KITTITAS COUNTY

MEMORANDUM

TO: All Staff
FROM: Public Works Plan Review Team
DATE: November 15th, 2023
SUBJECT: BL-23-00026 MTA Ranch

SHEET 1 OF 2

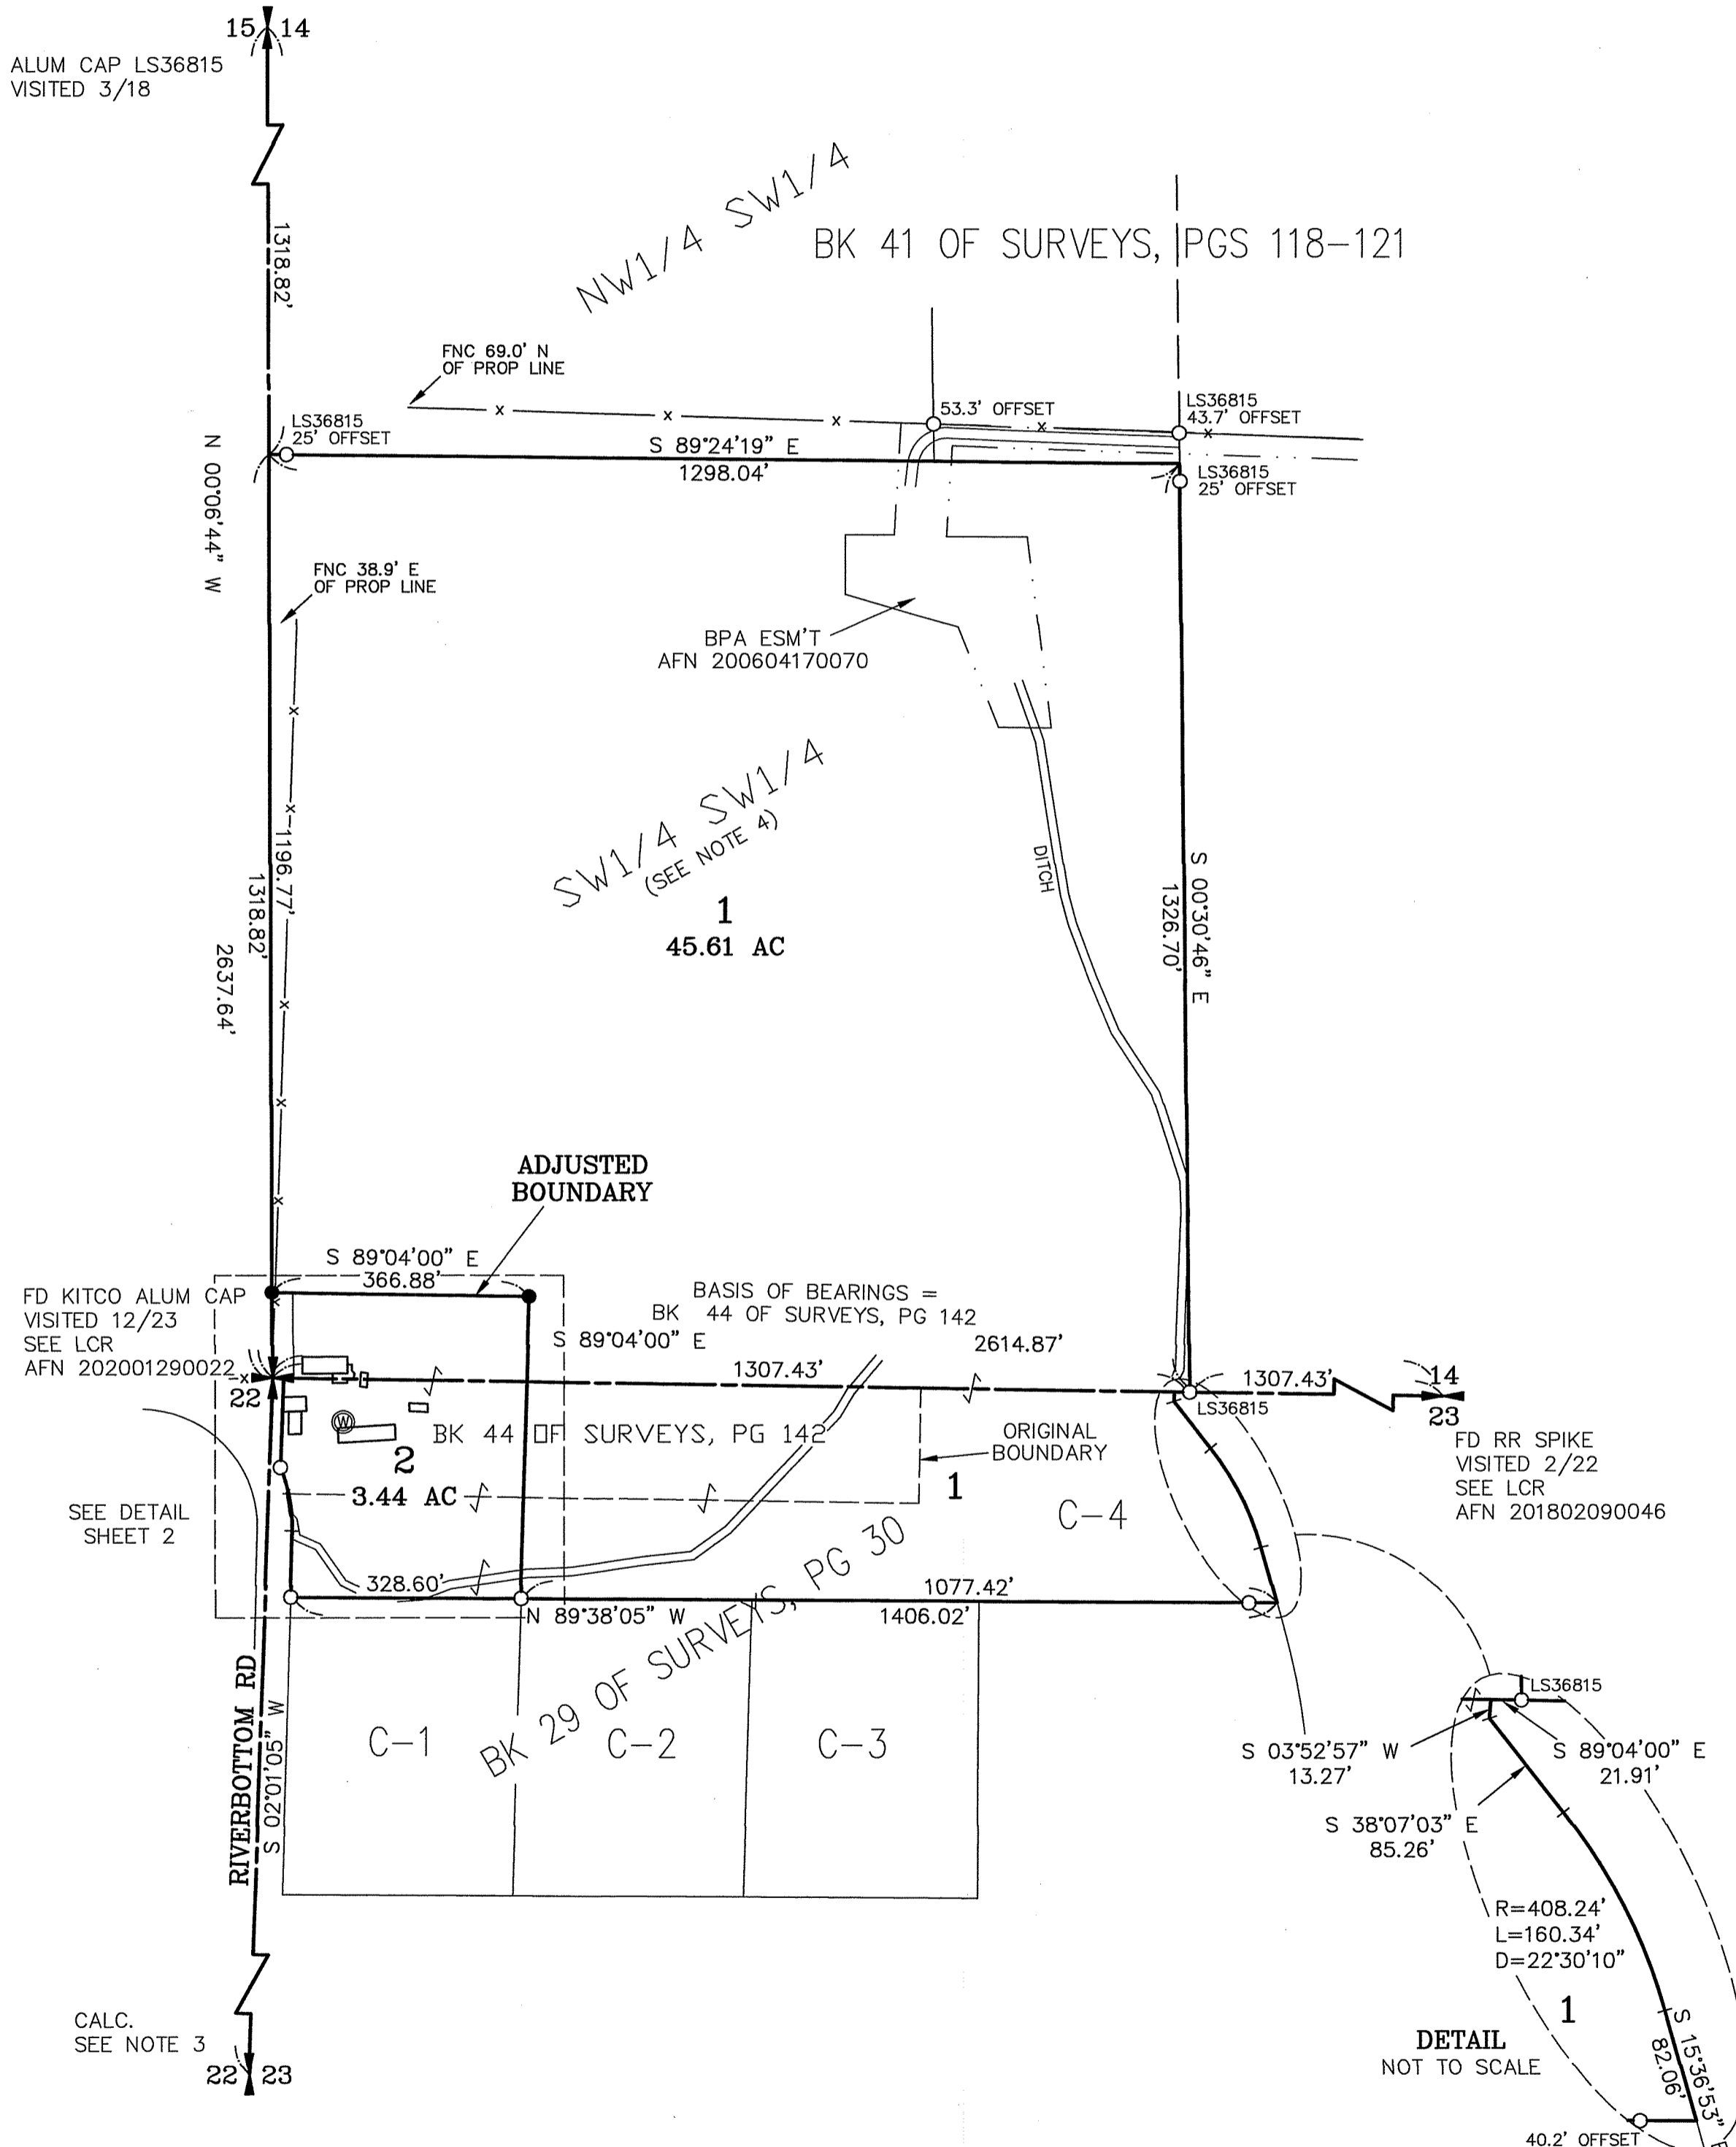
ACCESS	<ol style="list-style-type: none">1. Update 10/27/23-30 foot easement is required and shall extend to Riverbottom Road right of way. Must include 30 feet of Riverbottom Road frontage.2. An approved access permit shall be required from the Kittitas County Department of Public Works prior to creating any new driveway access or altering an existing access.3. Maintenance of driveway approaches shall be the responsibility of the owner whose property they serve. The County will not maintain accesses.4. Any further subdivision or lots to be served by proposed access may result in further access requirements. See Kittitas County Road Standards.5. In addition to the above-mentioned conditions, all applicable Kittitas County Road Standards apply to this proposal. Access is not guaranteed to any existing or created parcel on this application.
ENGINEERING	No Comments (CC)
SURVEY	<p>As the application does not contain a survey map, comments are reserved until final. (JT)</p> <p>UPDATE 12/27/2023 There are no survey changes required to this application.</p> <p>Of Note There MAY be usage lines or encroachments that should be shown, based upon aerial images, particularly along the fence deviation near the canal on the south edge of the development, and the usage of the irrigation pivot over the fields of both Siltman and MTA. (JT)</p>
